3	Cover letter - Archaeology and National Monuments	4	<p>1 Lissenhall Bridge (RMP DU011-081—; Protected Structure No 341 (Fingal)) Lissenhall Bridge is a Protected Structure and Recorded Monument as well as a National Monument under the criteria defined in Section 2 of the National Monuments Act 1930-2004. The bridge originally dates from the late medieval period and elements of this medieval structure are clearly identifiable within the extant bridge structure. This has been confirmed by a number of recent surveys as outlined in Table 25.6 of the EIAR. The EIAR has correctly identified that likely significant effects to this National Monument could occur at Construction Stage as a result of nearby construction works (particularly necessary piling works) and also from the transit of construction vehicles. The proposed mitigation measures to be implemented are vibration monitoring and the hoarding off of the bridge during construction to prevent all but pedestrian access (see Table 25.9). Chapters 13 and 14 of the EIAR clearly set out the general vibration threshold limits that will be applied in relation to historic structures and Table 25.9 further notes that the thresholds implem

Drawing Title
Arboricultural Impact
Lissenhall
15 of 108

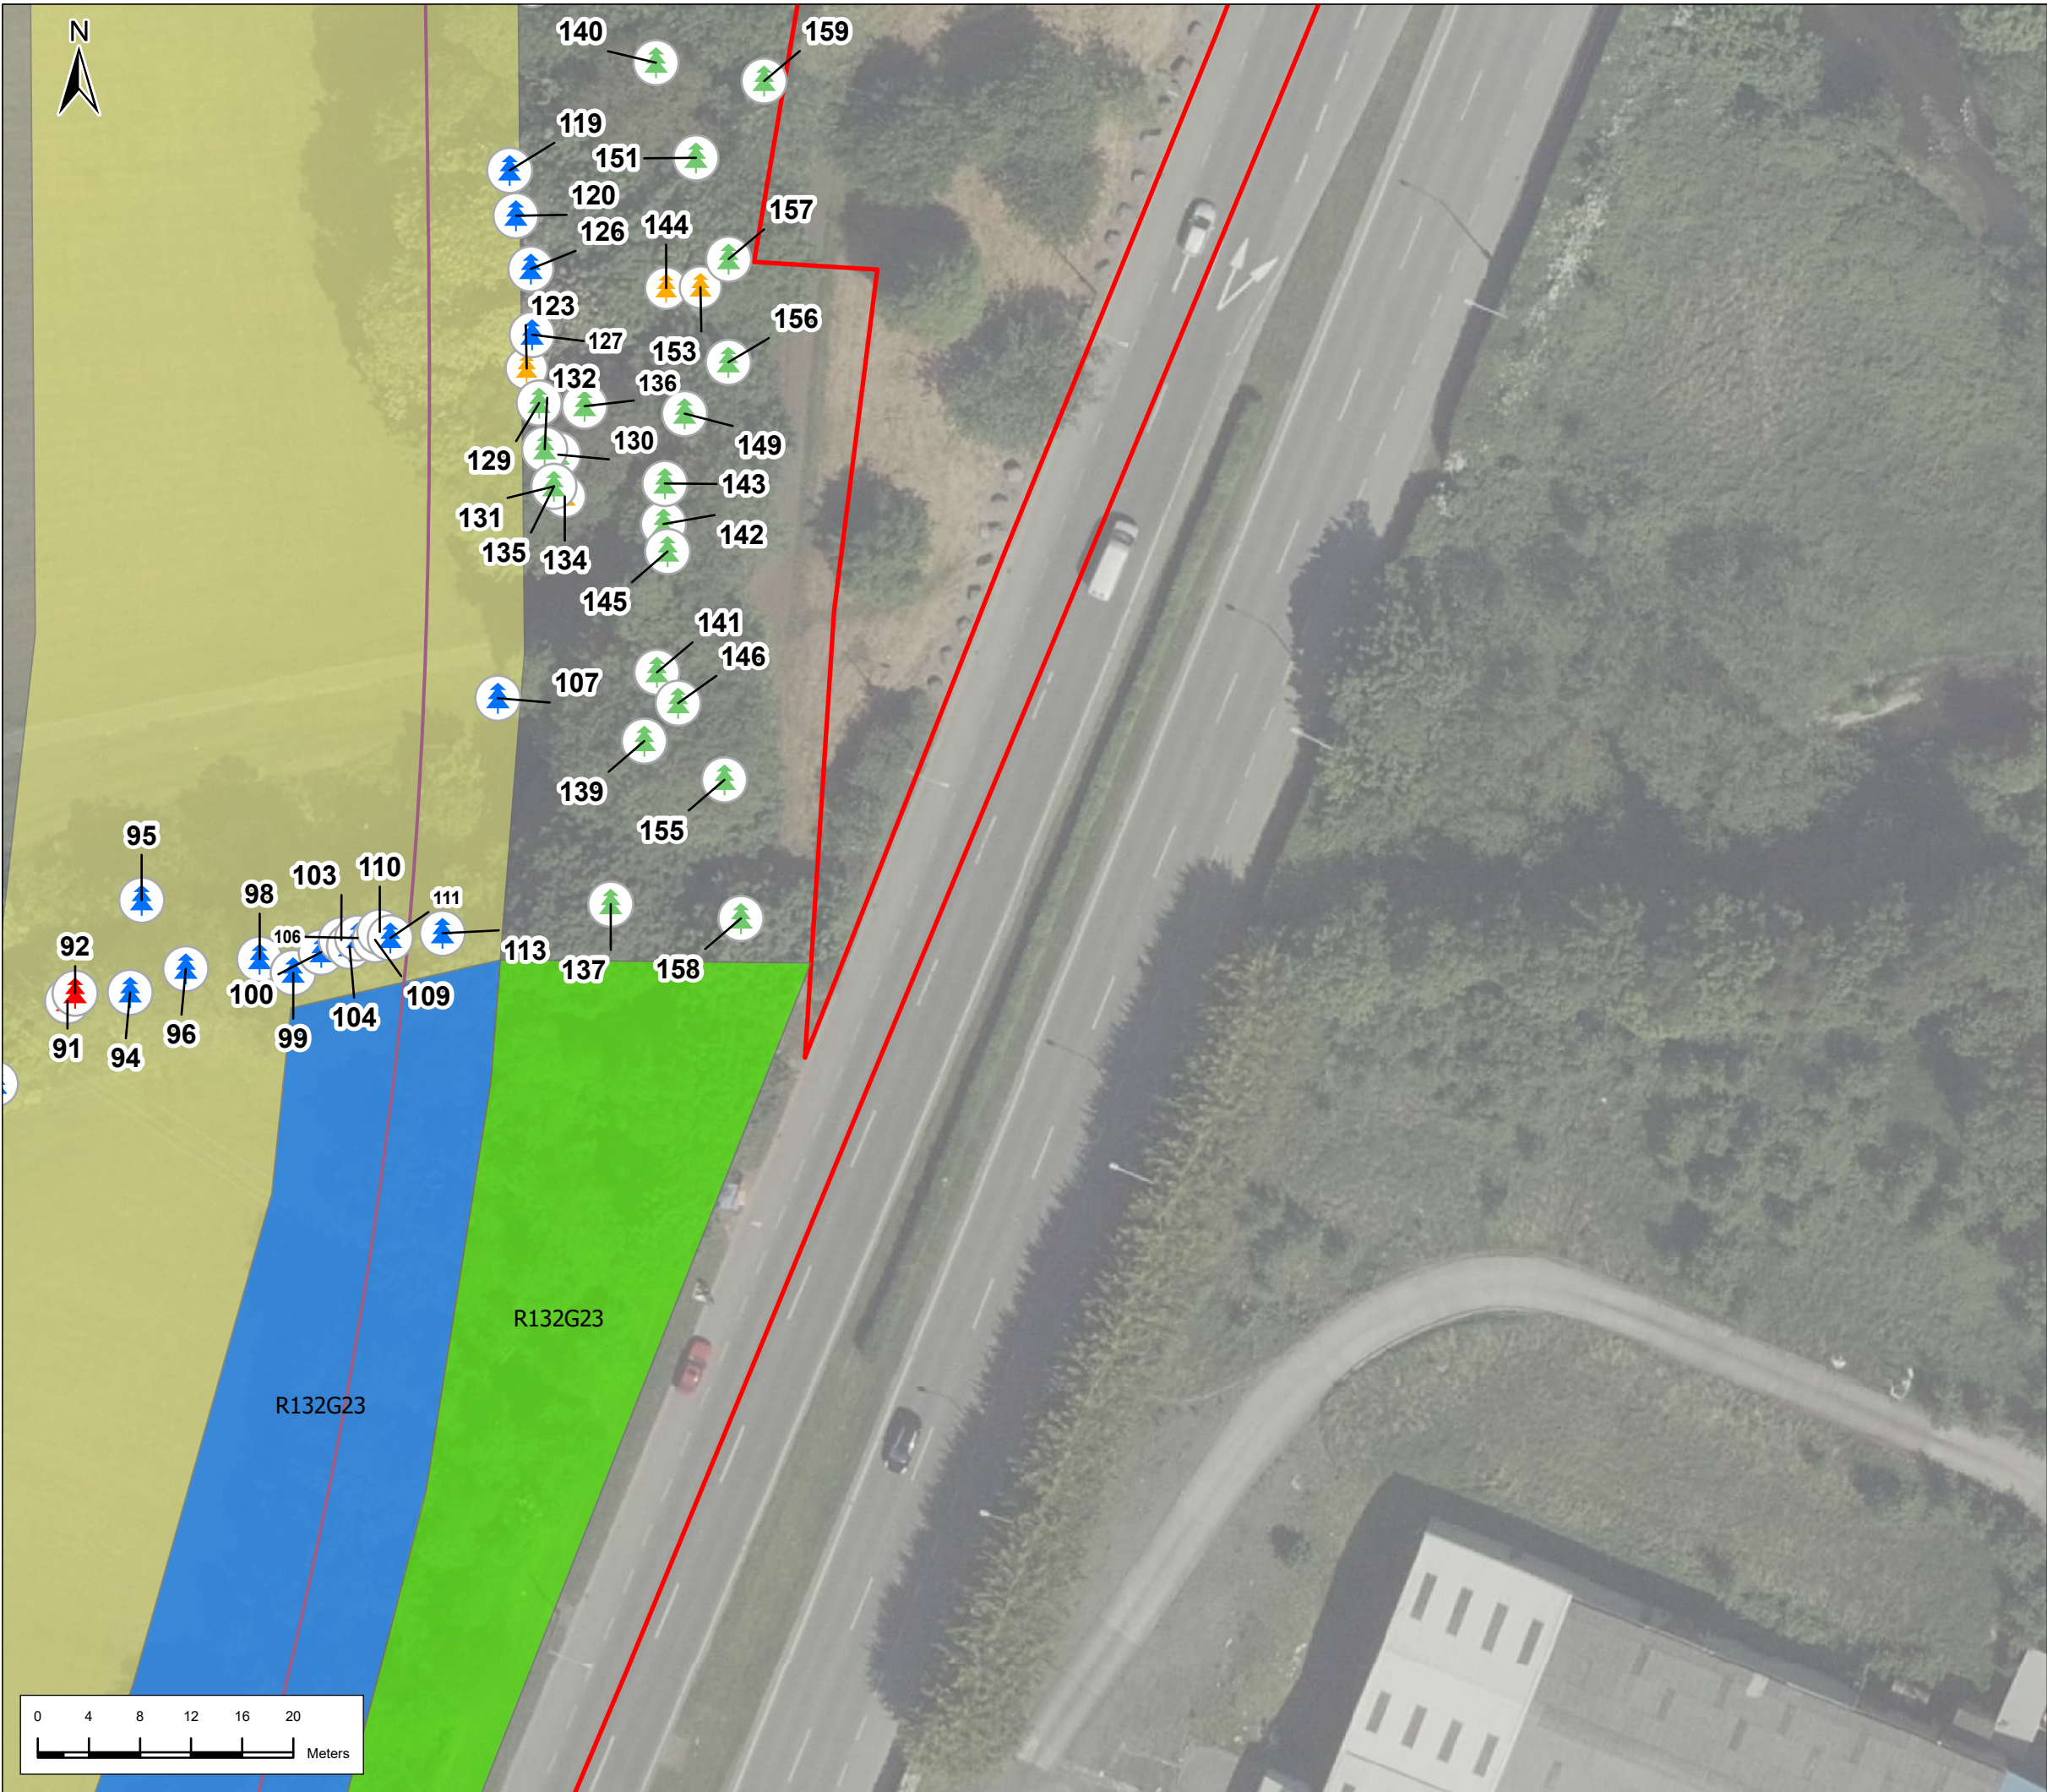
15	Cover letter - Site specific recommendations and observations	11	<b>Lissenhall Bridge</b> The Department would welcome careful consideration and the provision of detailed survey of this early structure and its historic setting as it retains cultural significance and integrity. Further information is necessary to understand the overall condition and structural capacity to inform the level of intervention and to minimise adverse impact on the bridge's historic character. Due to the scale of the proposal insufficient information is available to ascertain the overall impact to this protected structure/monument and to gauge the proposed conservation outcome	As noted by Response (3) above, the EIAR identifies, describes and assesses all significant impacts of the project on the Bridge. Hoardings will be located and designed to ensure there is no risk to the Lissenhall Bridge structure from construction works, plant and equipment, and that there are no proposals for construction work to occur within 10m of Lissenhall bridge.  TII commit to procuring the main works contractor to undertake further surveys and assessments prior to commencement of works (in order to update existing surveys and results and data held) to ensure that the Lissenhall bridge is protected from the MetroLink works. In the unlikely event these assessments dictate that further protection measures are required, TII will agree with the Department the form and nature of any measures required. The assessments and mitigations will respect the bridge's historic setting and cultural significance.
